RE: 84 Woodhead Road, Holmbridge - 2021/91568 - KC Conservation & Design Comments

I can confirm that these would appear to address my previously stated concerns (see Consultation response dated 18.June 2021) and that I have no further objection to the application.

DRAWING NO.
1027-05

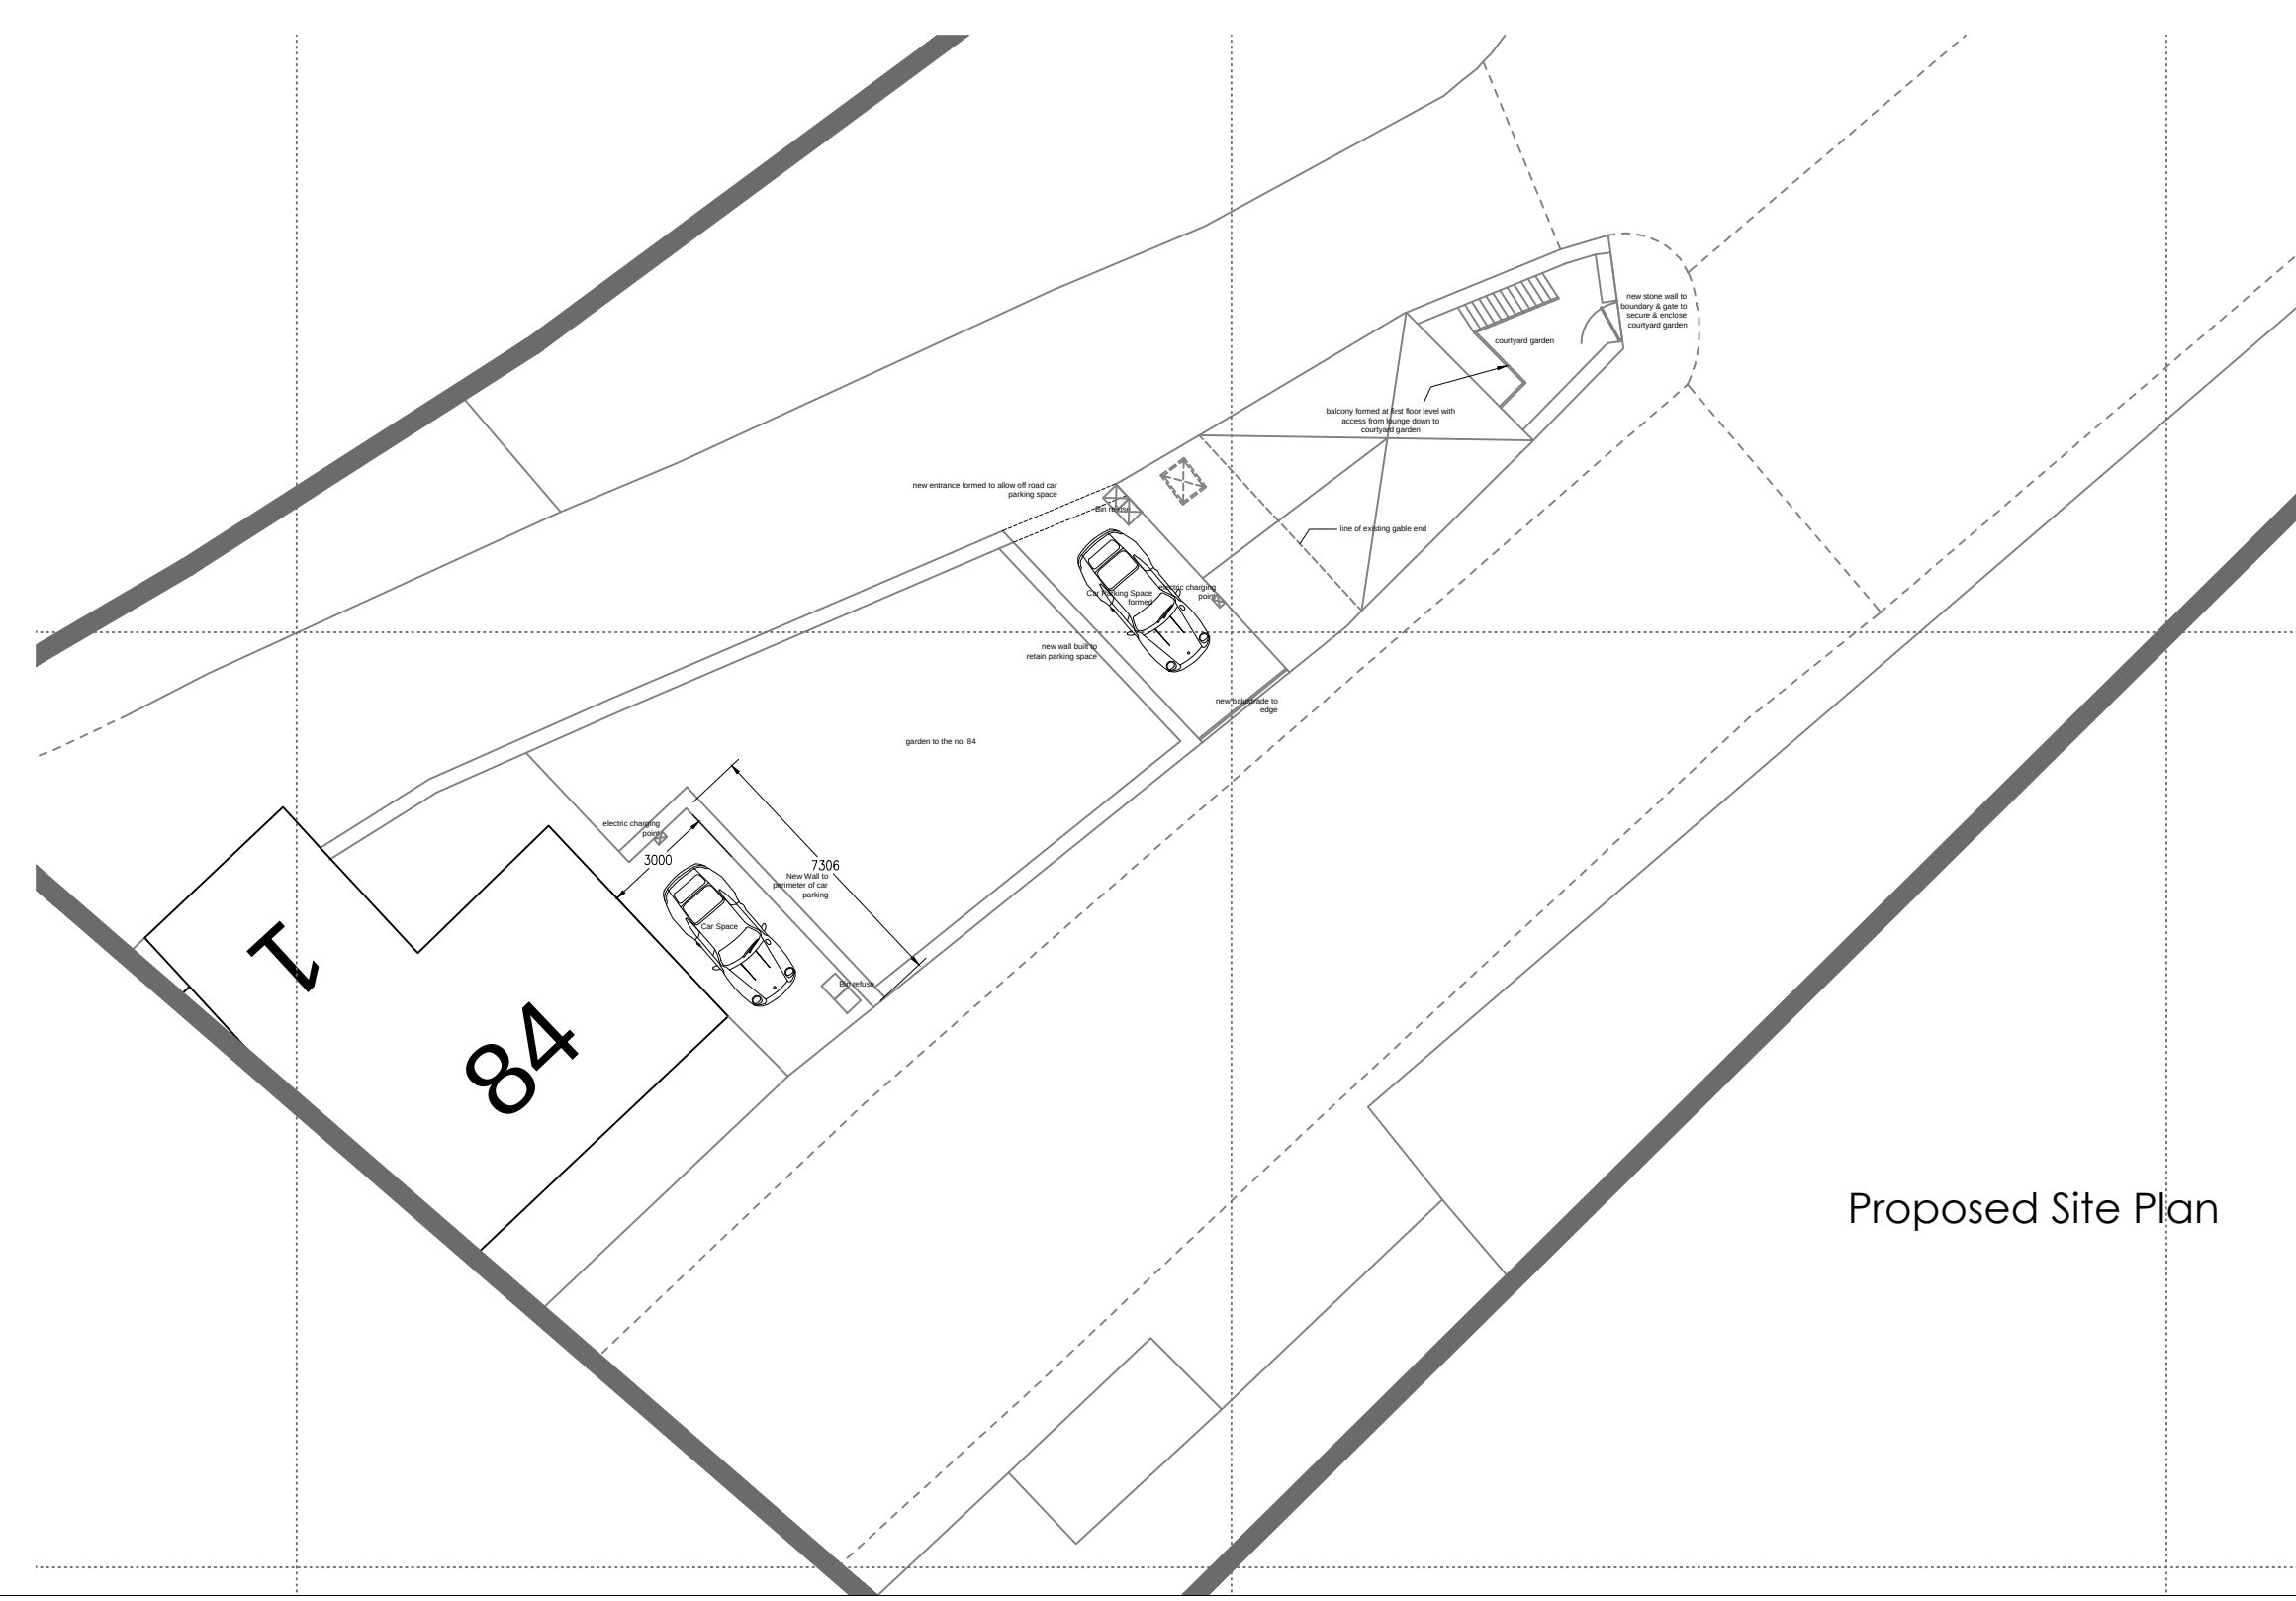
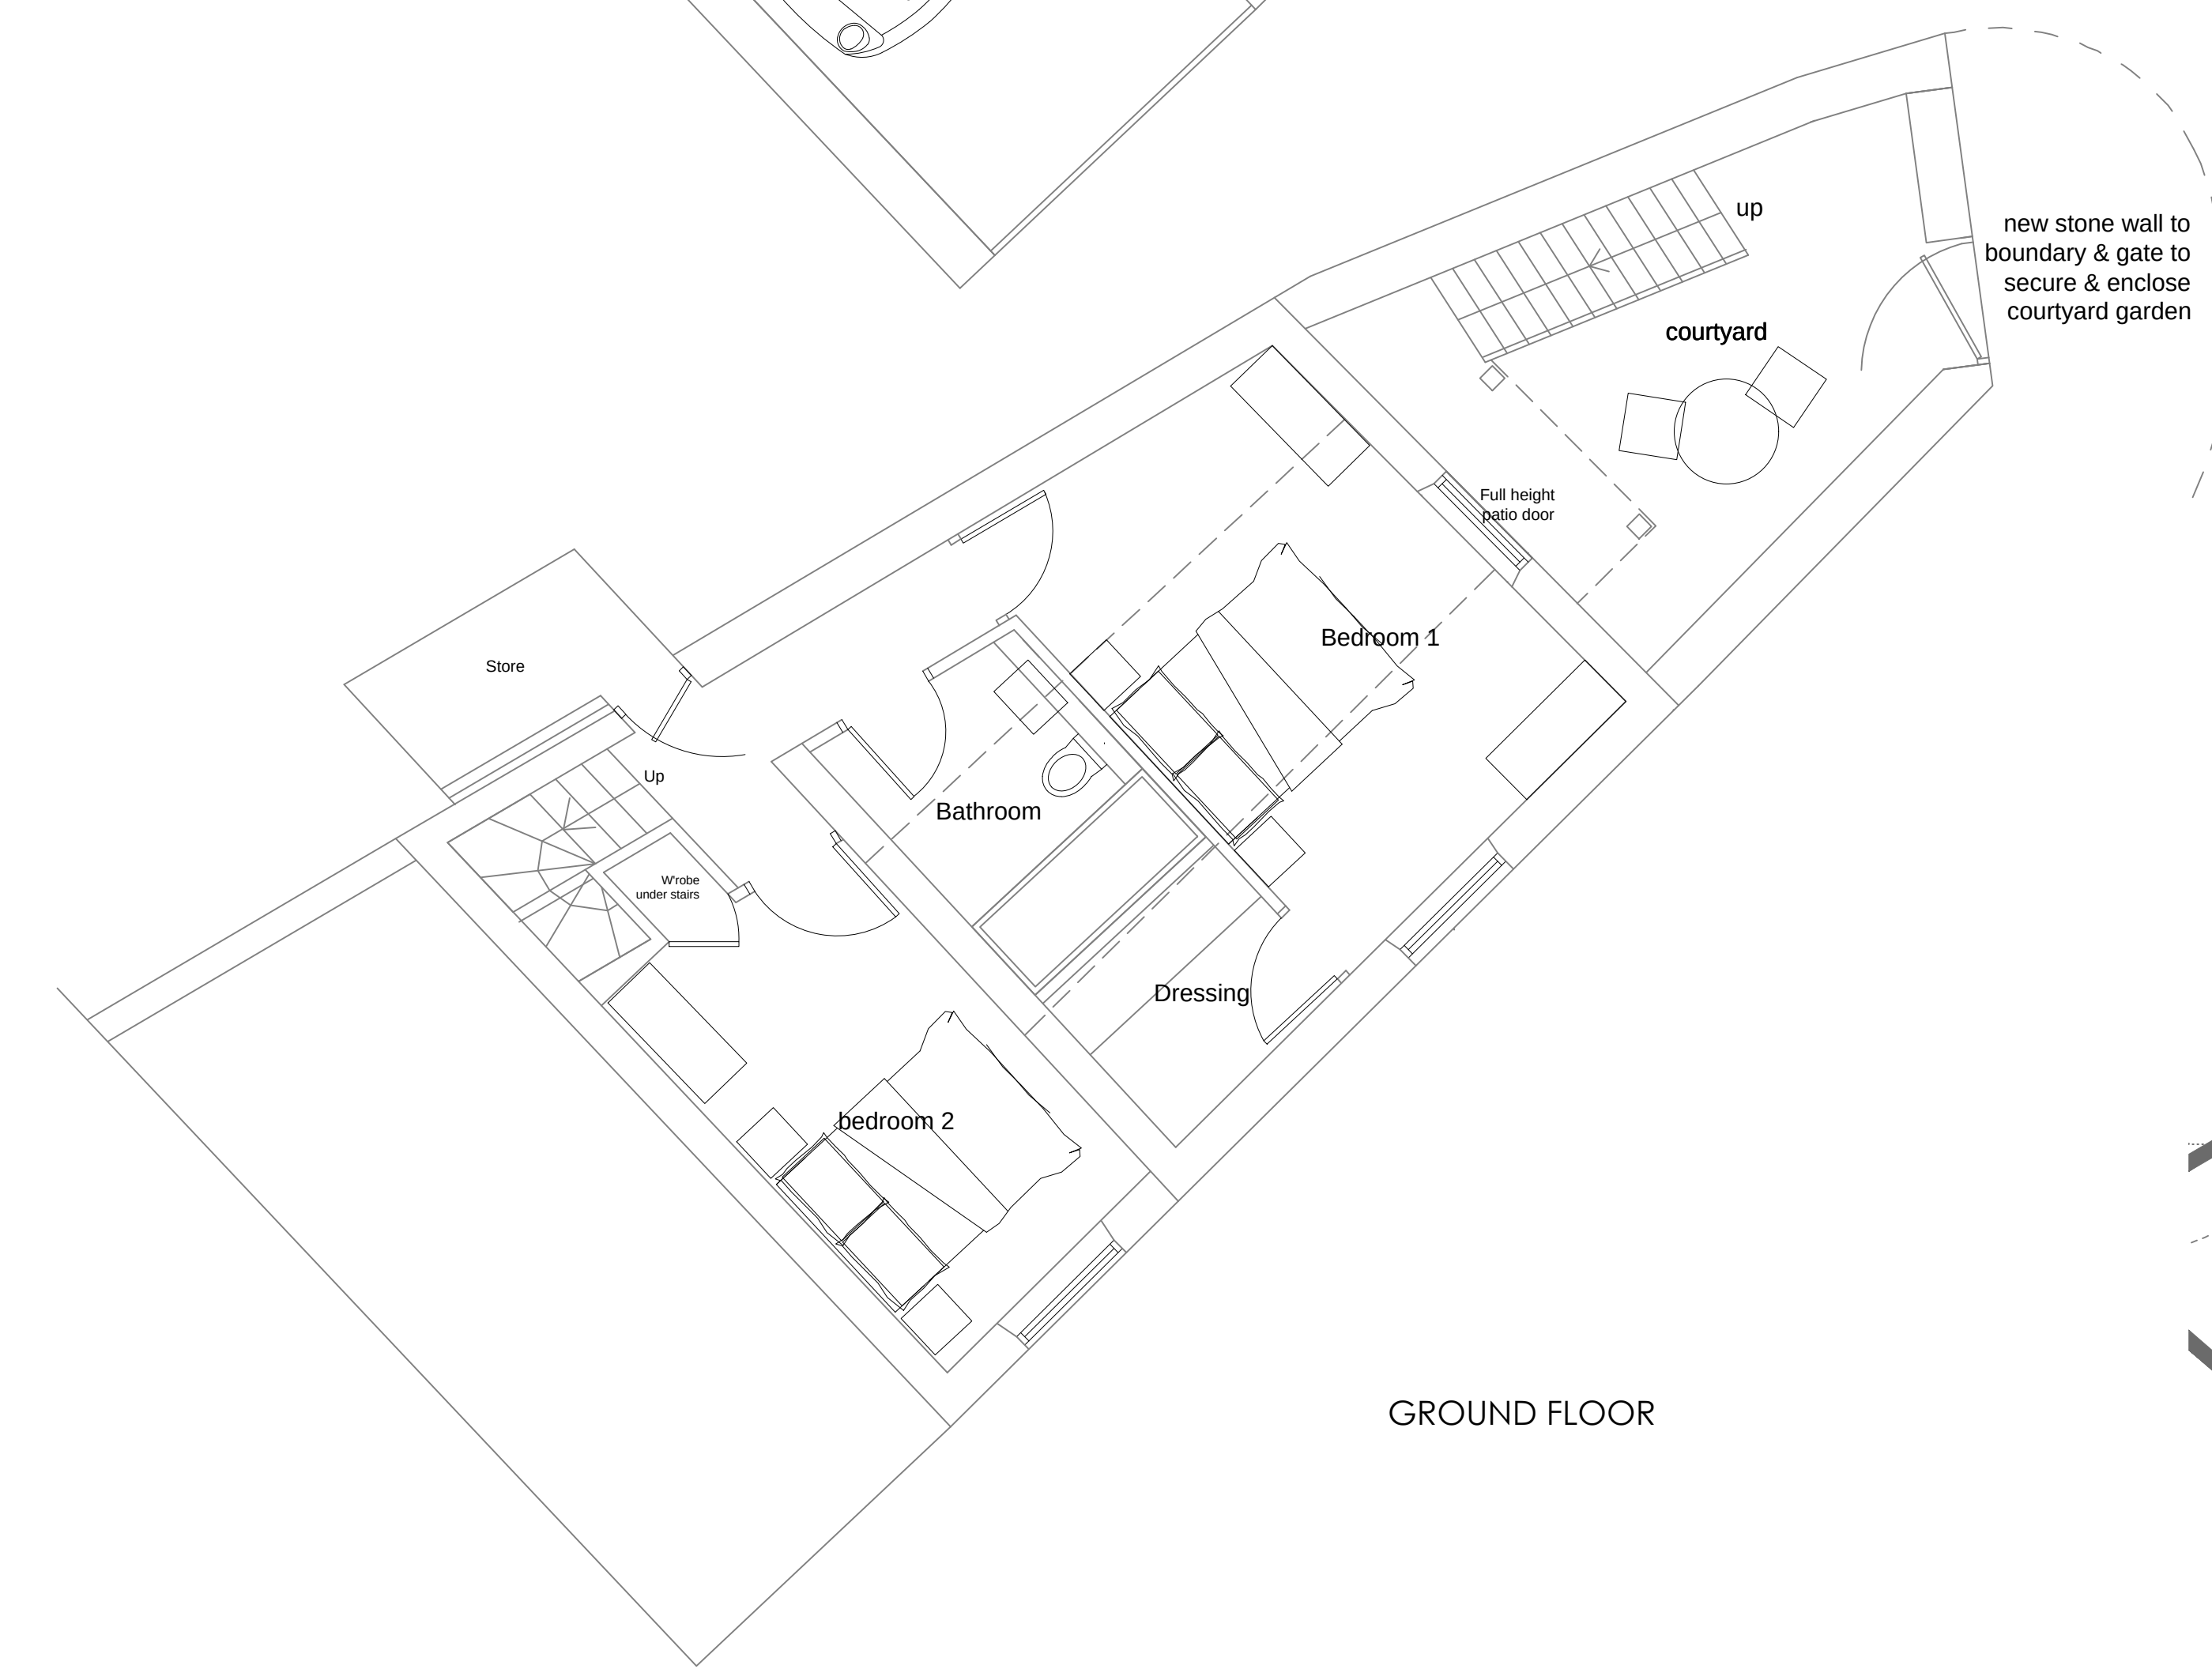
To make it clearer, would you mind adding an annotation to this elevation to say that the boundary wall has been demolished to create a new vehicular access? This would make it clearer to other people viewing the plan.

From your earlier email, I understand that vehicular access and parking are to be off Fairfield Road and that a raised parking platform would be constructed to facilitate this. However, the elevations do not show a new vehicular access on the Fairfield Road elevation, just a small pedestrian access gate. This should be changed so that the proposed new access is clearly shown and annotated on the Fairfield Road elevation.

Please find attached amended prop plans as per your request.

Apologies I missed your call, I was in an appointment, please find attached prop plan, it was showing an older version of the fairfields road elevation, so please find the correct elevation.
